Your Ref: OWPC18131
Our Ref: M/41/18/HH 22-03-2018
Please ask for:
Zac Denton

Extension to 1st floor incorporating rooms within the roof space for new 2nd floor & single storey rear extension with balcony above.

25 Sea Way Middleton-On-Sea

PROPOSED ELEVATIONS

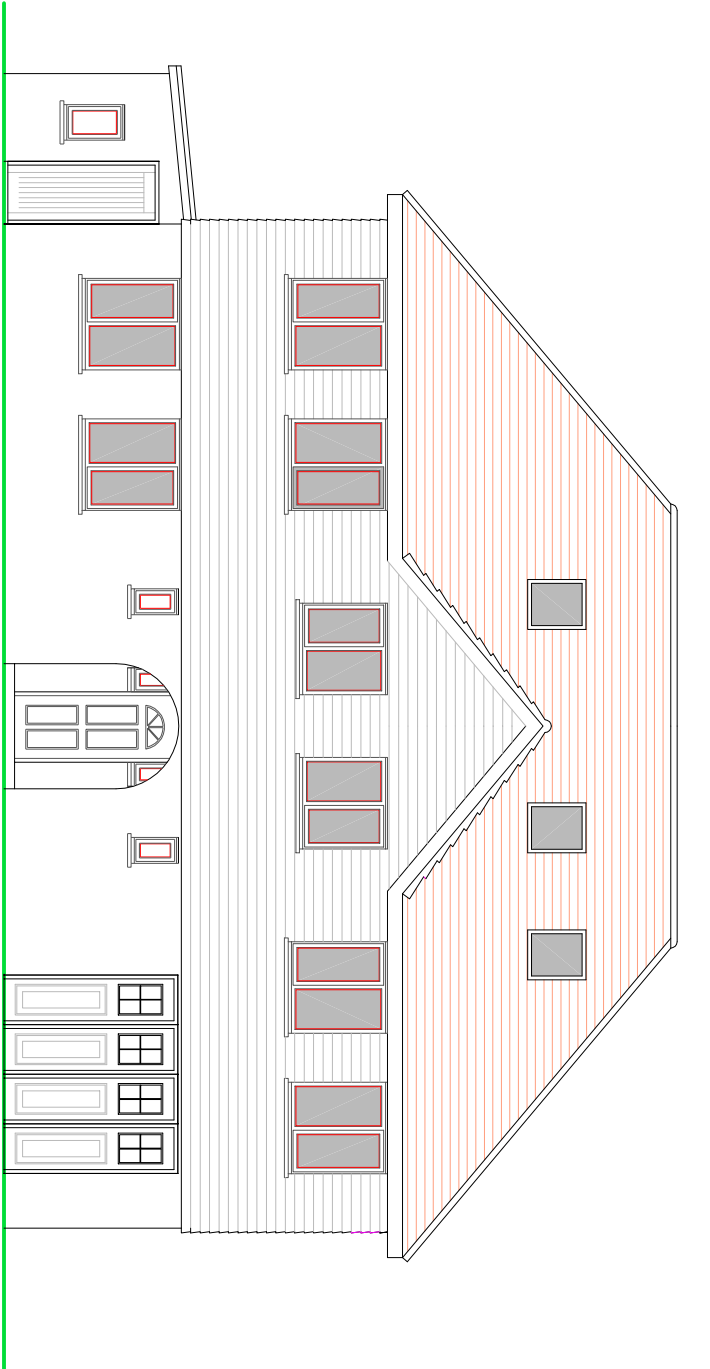
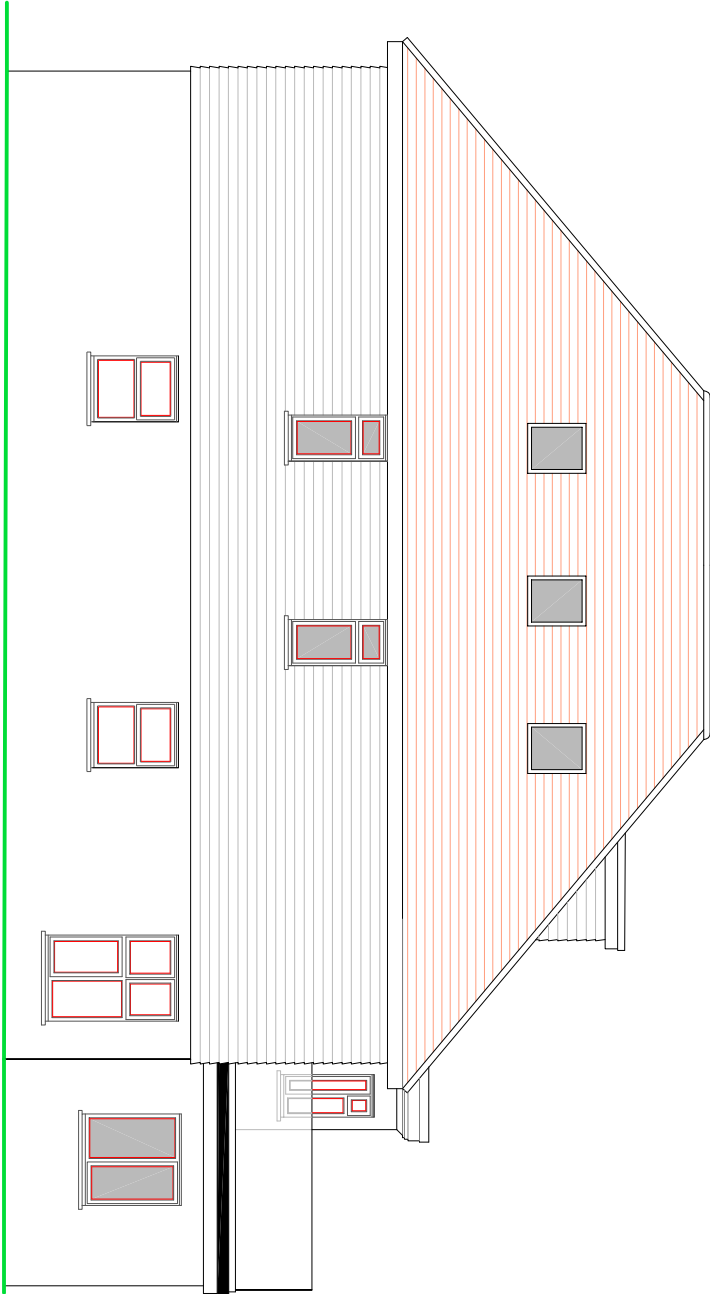
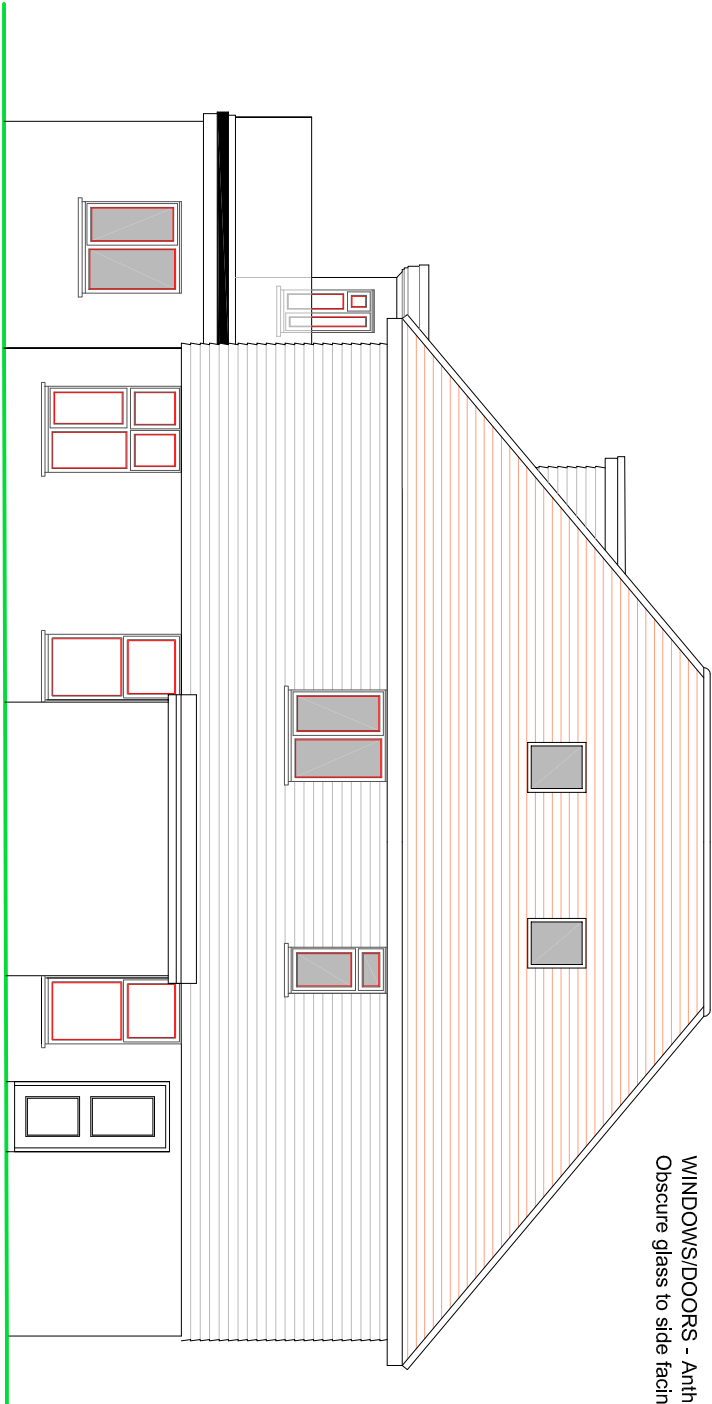
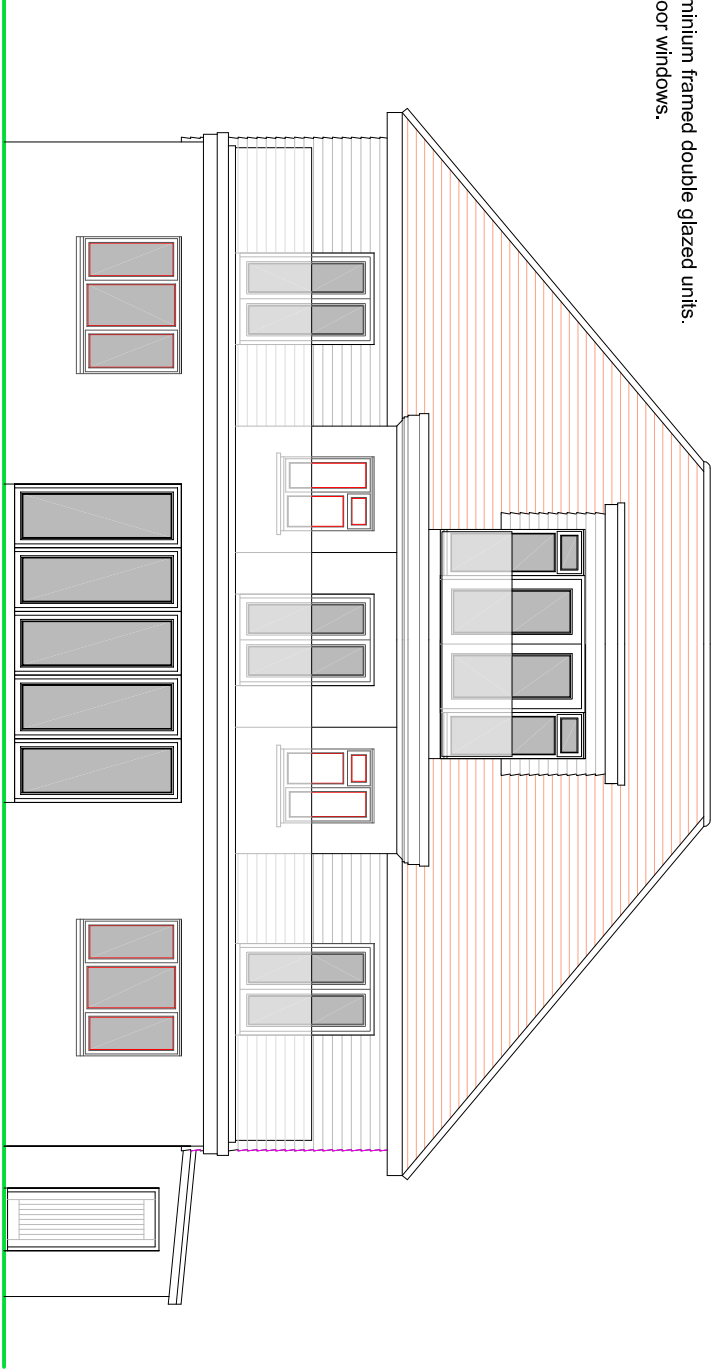
- 1. 'Three storey buildings are not in keeping with the Character and must be avoided' - The raising of the roof by over a metre and the creation of a gymnasium, bedroom, bathroom, store and balcony is clearly a third floor*
- 2. 'Skylights should sit flush with the roof and be avoided in front elevations' - The plans show three skylights on the front elevation*
- 3. '.....maintains the privacy enjoyed by neighbouring properties....' - The third floor balcony would be grossly intrusive for the adjoining properties both to the East and West*
